PROPOSED NEW
TENANT SPACE UPFIT
4318 RAY RD
SPRING LAKE, NC 28390

Reviewed for Fire Code Compliance

Harnett
COUNTY
NORTH CAROLINA

11/07/2025 9:48:11 AM

2 Life Safety Plan
1/4" = 1'-0"

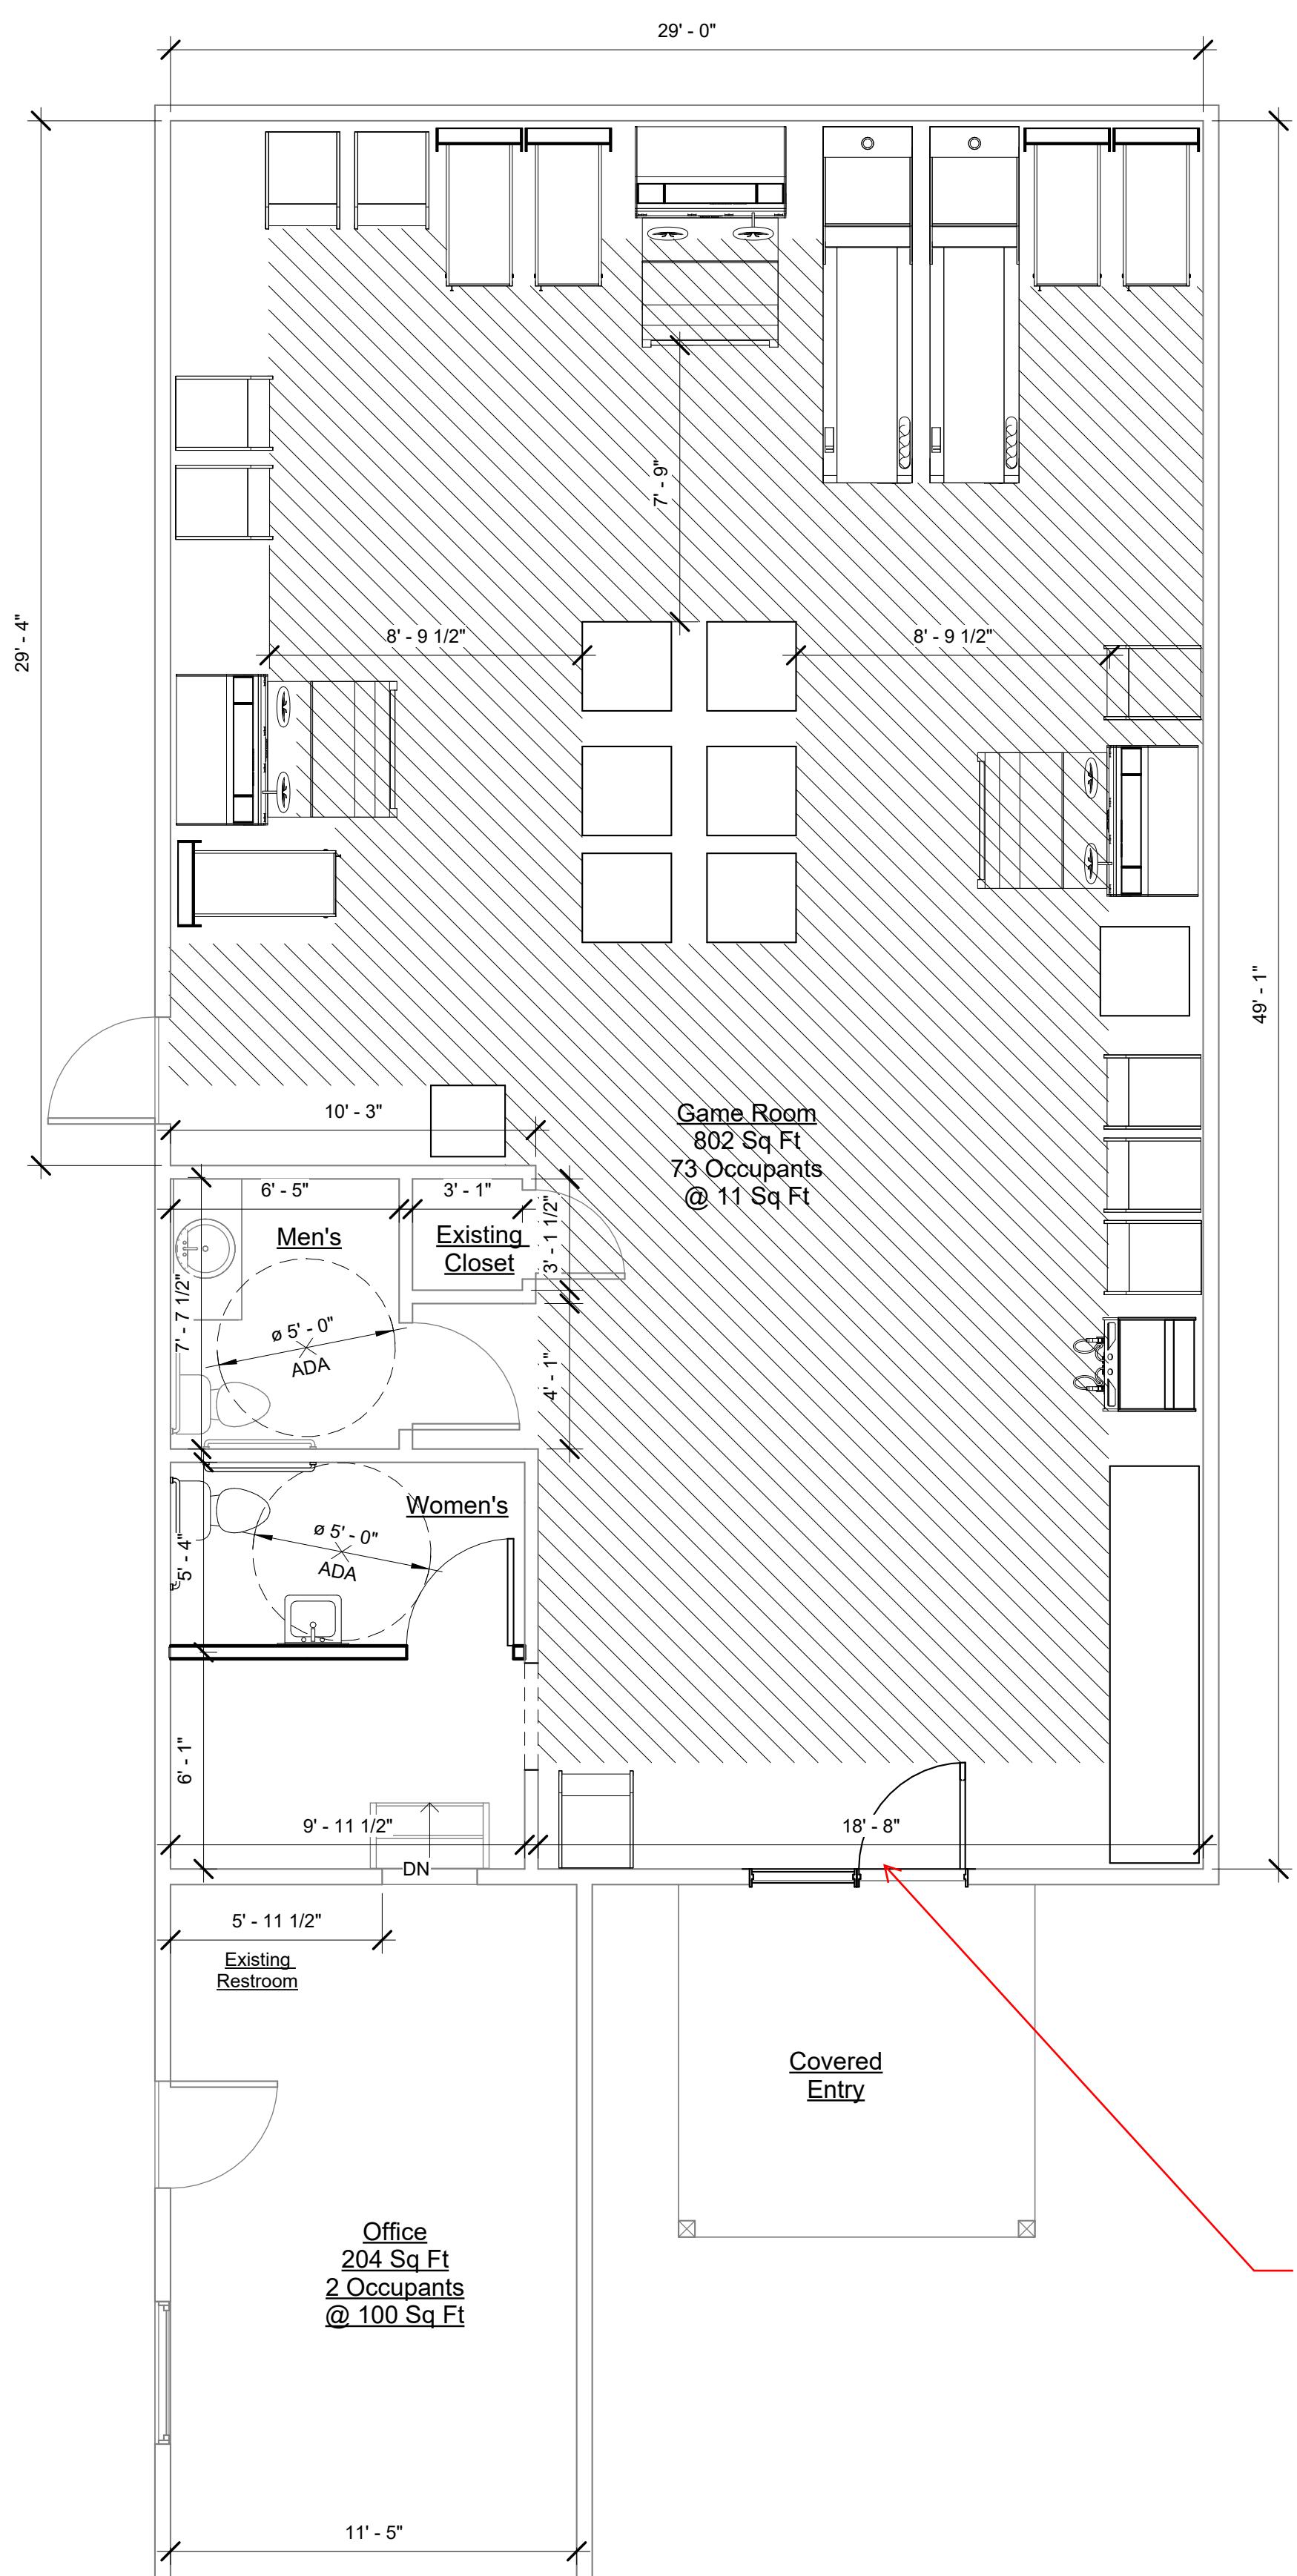
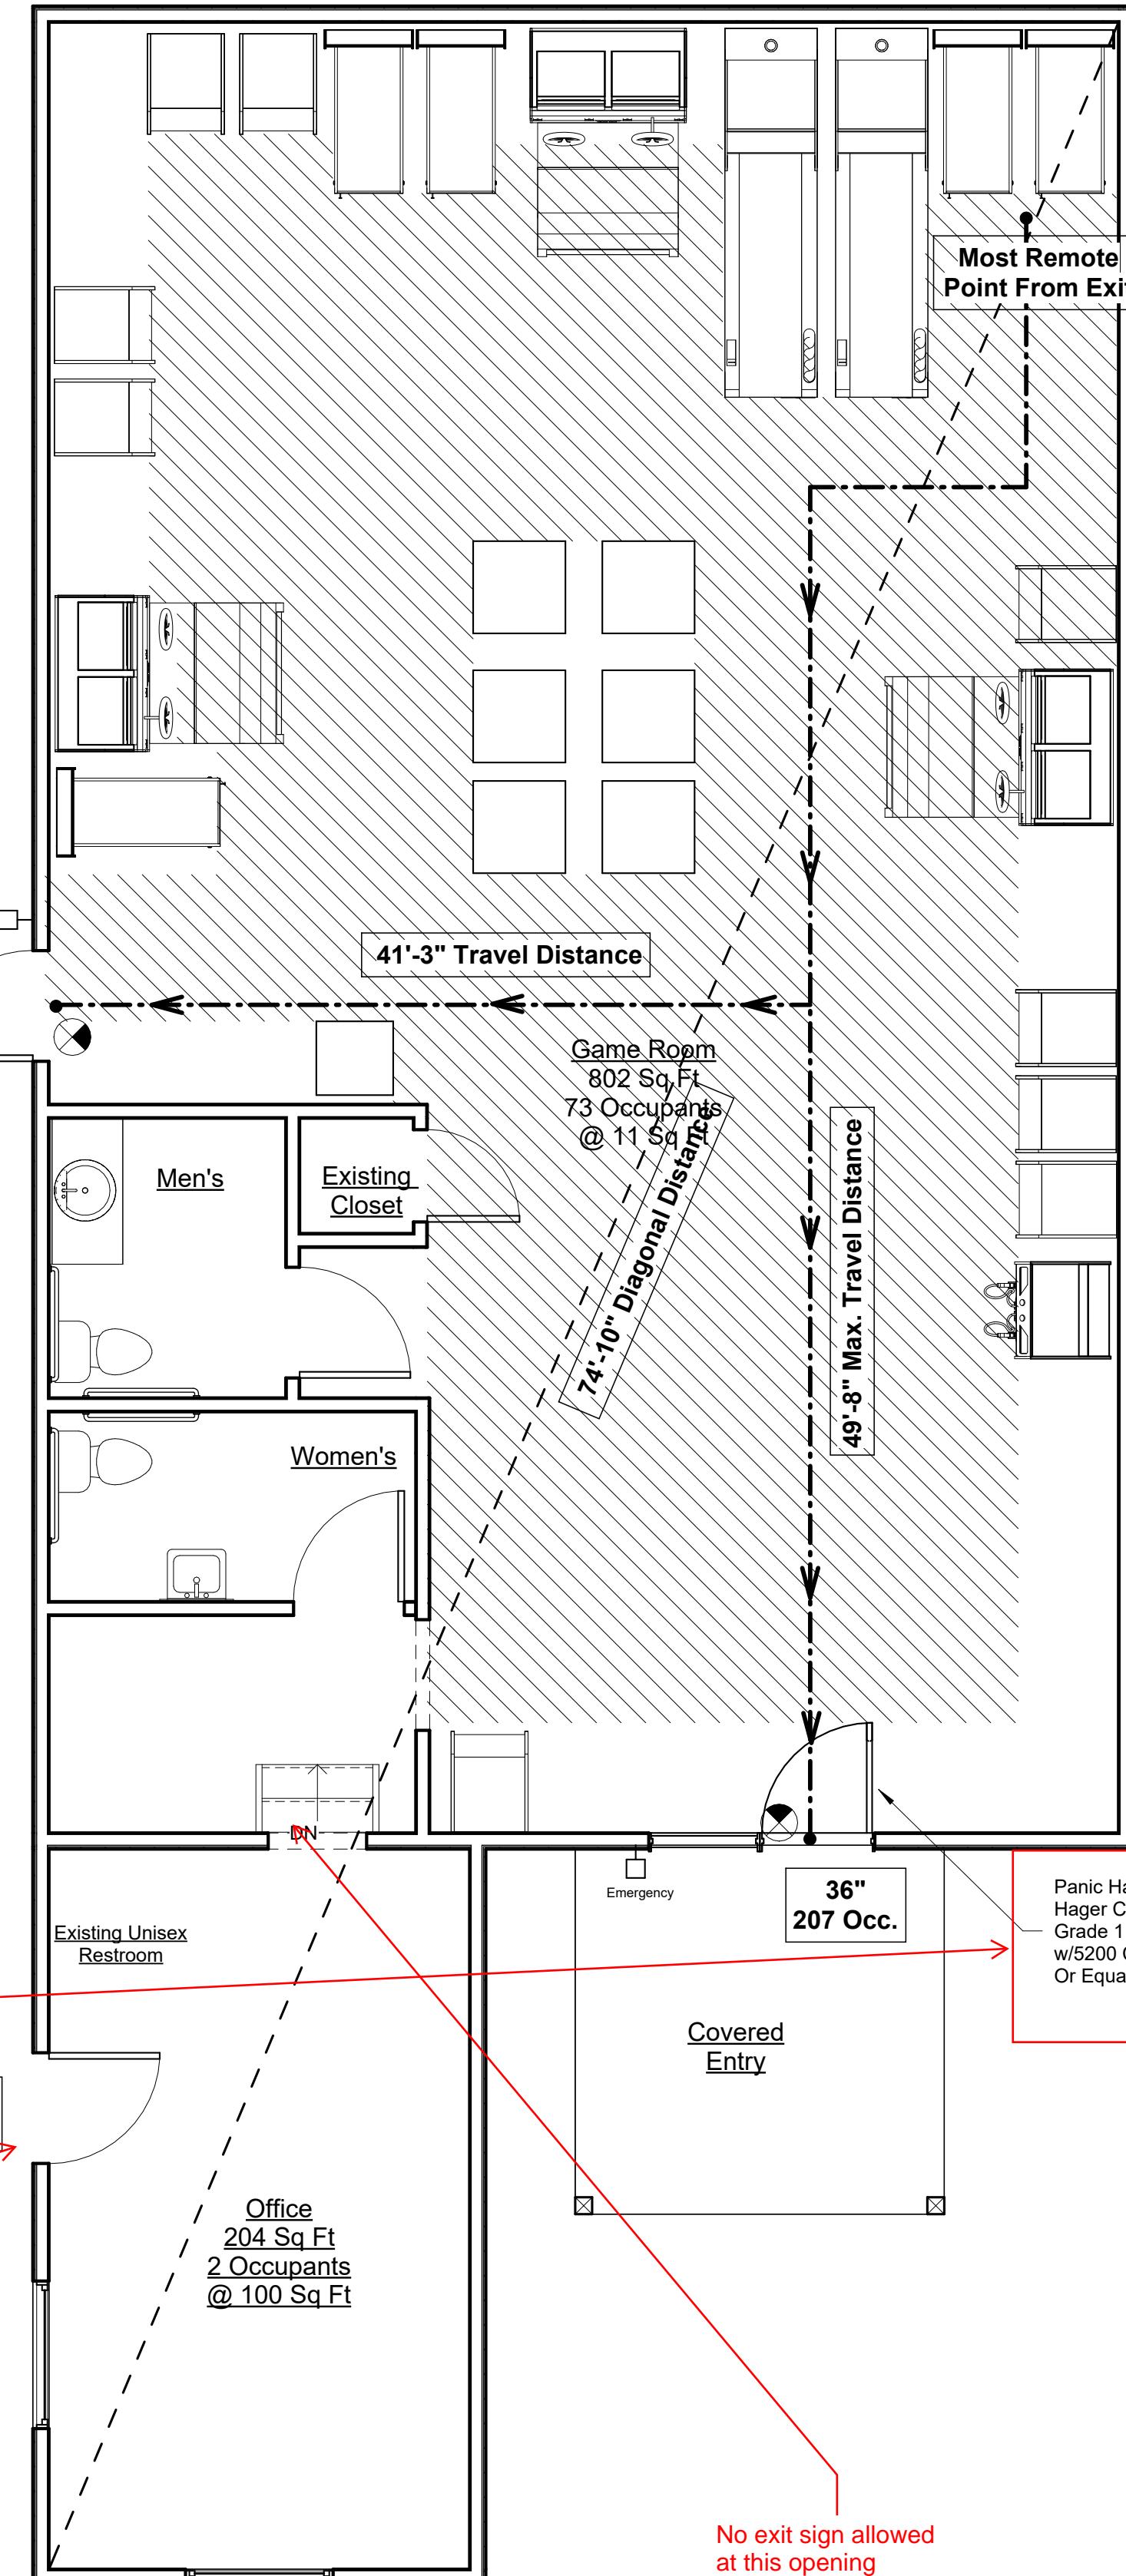
Per conversation with Mr. Horton, this door to be moved to obtain at least 37 feet separation between exits.

Both exits to have panic hardware

Garage door shall be removed or mechanically secured so it cannot be closed

This door to remain as is.
